Current Zoning: B-1 (neighborhood business)
Proposed Zoning: MUDD-O (mixed use development, optional) with three-year vested rights

Approximately 0.34 acres located at the southwest intersection of Seigle Avenue and Belmont Avenue, north of Harrill Street.

The petition proposes rezone a lot previously used as an auto car garage to allow the construction of a 9,000-square foot mixed-use building residential and nonresidential uses.

**SITE PLAN** SCALE 1:20

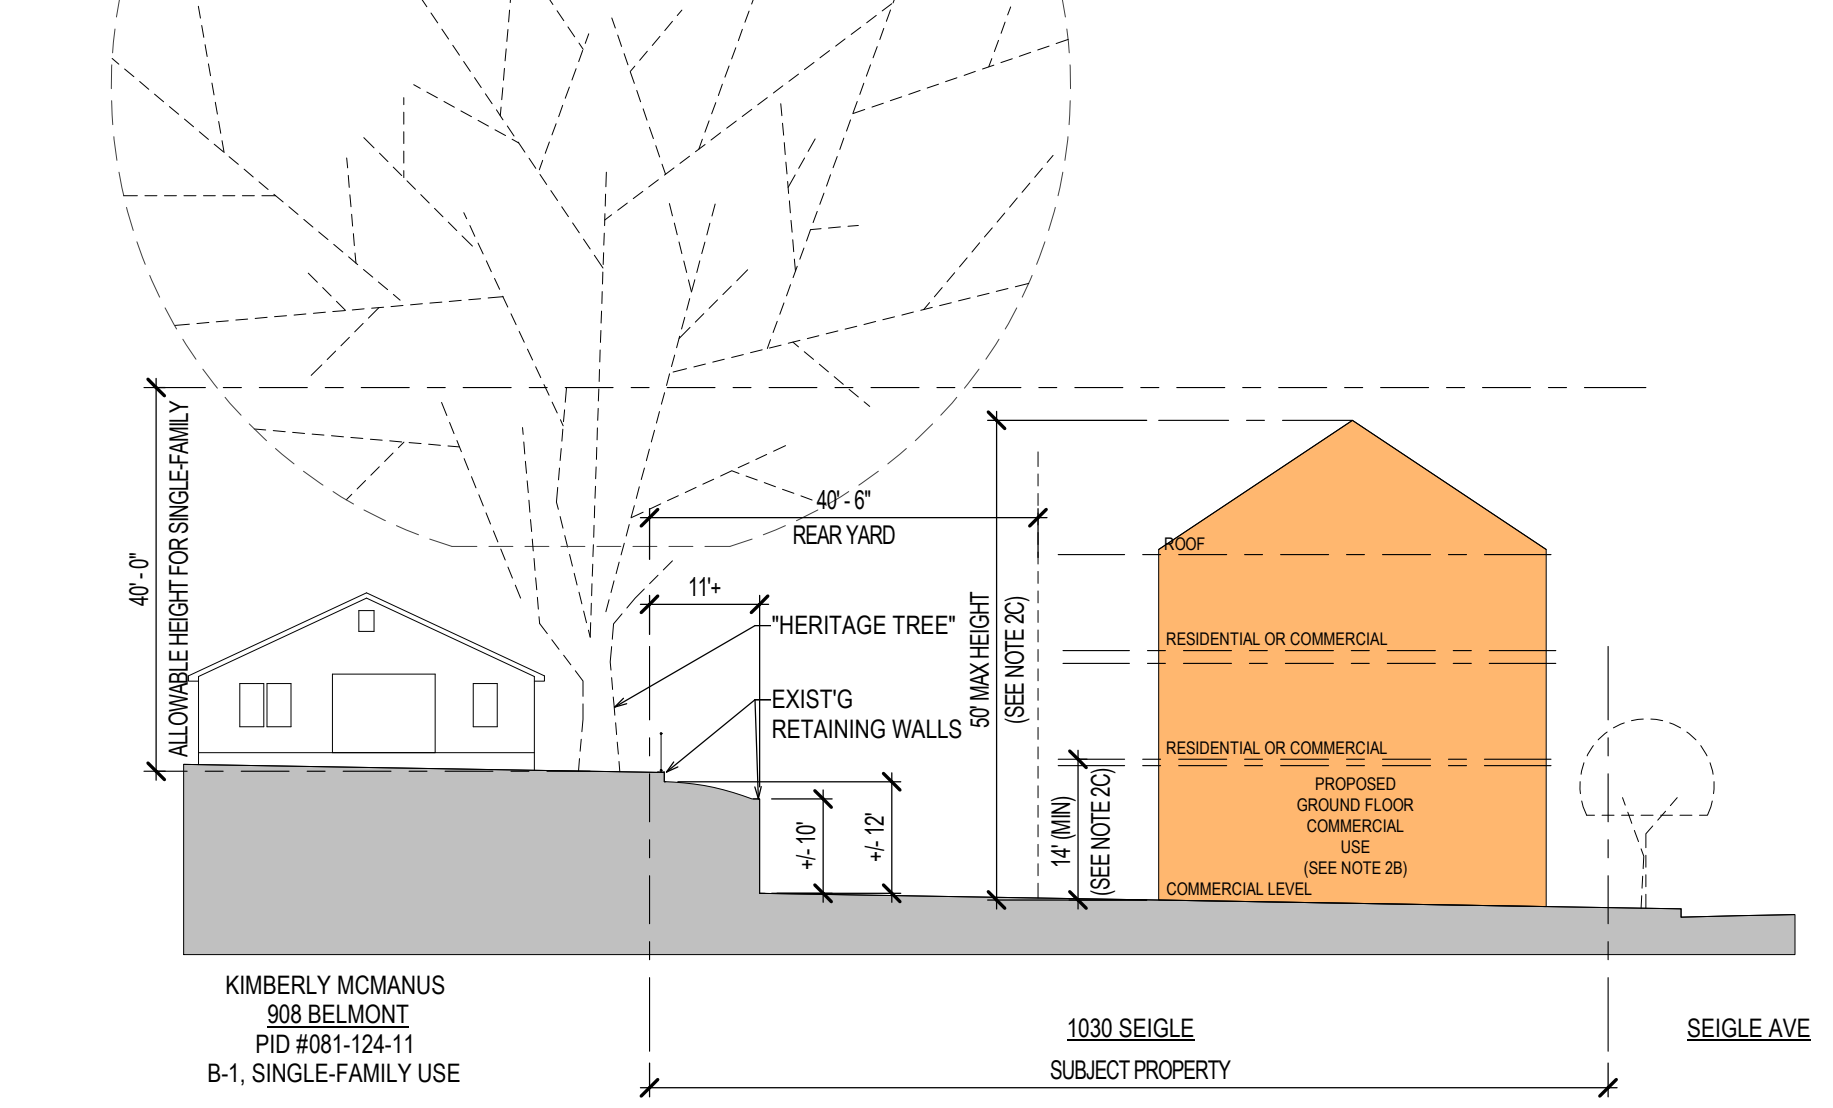
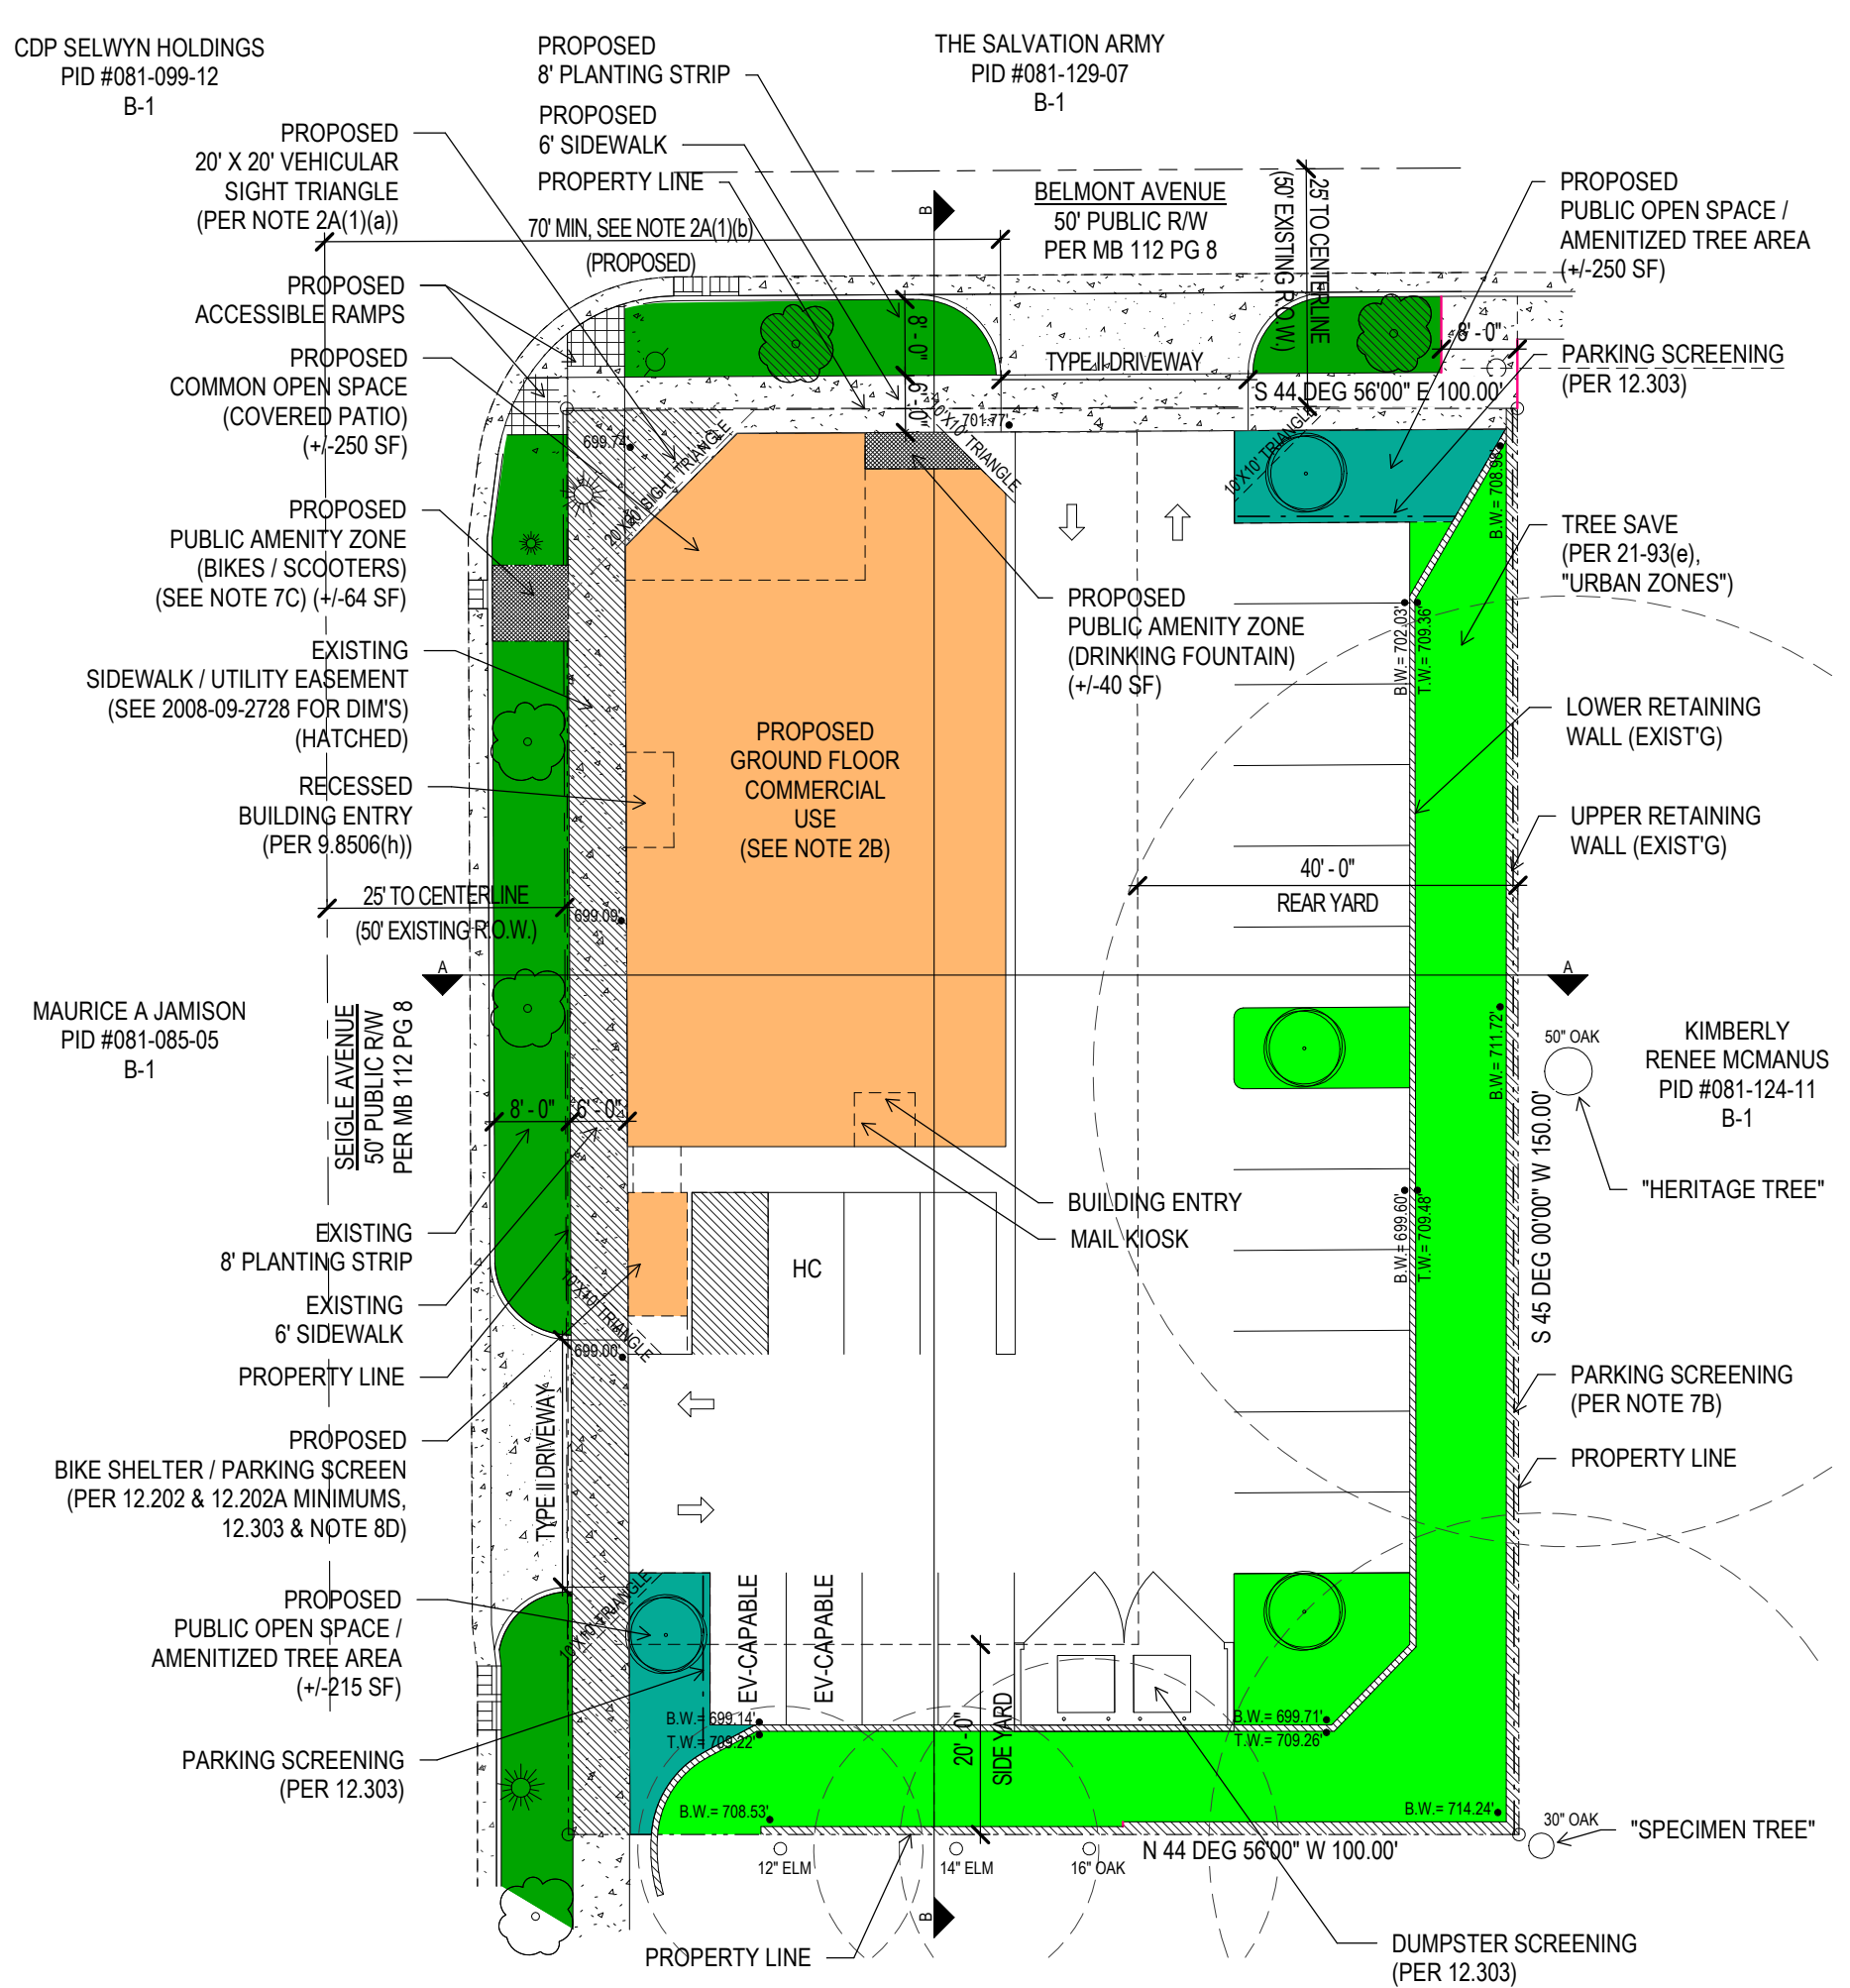
1. Existing curb and gutter can remain in existing location but label and dimension the future curb and gutter location from the centerline for each road on the site plan.

2. The site plan shall label and dimension the right-of-way from the road centerline. Site plan shows 25' to centerline but does not show the existing 50' from centerline. Label and dimension the existing 50' right of way from centerline of road.

3. CDOT REQUESTS petitioner commit to 8' sidewalk and place Streets Map streetscape behind future curb location.
4. Add a conditional note specifying "A Right-of-Way Encroachment Agreement is required for the installation of any non-standard item(s) (irrigation systems, decorative concrete pavement, brick pavers, etc.) within a proposed/existing City-maintained street right-of-way by a private individual, group, business, or homeowner's/business association. An encroachment agreement must be approved by CDOT prior to construction/installation. Contact CDOT for additional information concerning cost, submittal, and liability insurance coverage requirements."

5. Add a conditional note specifying "the Petitioner shall dedicate and convey in fee simple all rights-of-way to the City before the site's first building certificate of occupancy is issued. CDOT requests rights-of-way set at 2' behind back of sidewalk where feasible."

6. Petitioner should revise the site plan and conditional notes to show sidewalk utility easement on plans behind proposed sidewalk.
7. Petitioner should revise the site plan and conditional notes to show 10x10 triangles behind the sidewalk.

8. Review urban tree requirements. While the 10' no build zone can be counted towards tree save there must still be a minimum of 10' of replanted tree save. (20' total width) Trees cannot be planted within 10' of a structure/retaining wall. Utilities such as transformers are not permitted within trees save or amenitized tree save.
9. Trees outside of the property line cannot count towards any requirements. Trees must be completely on the property to count towards requirements.
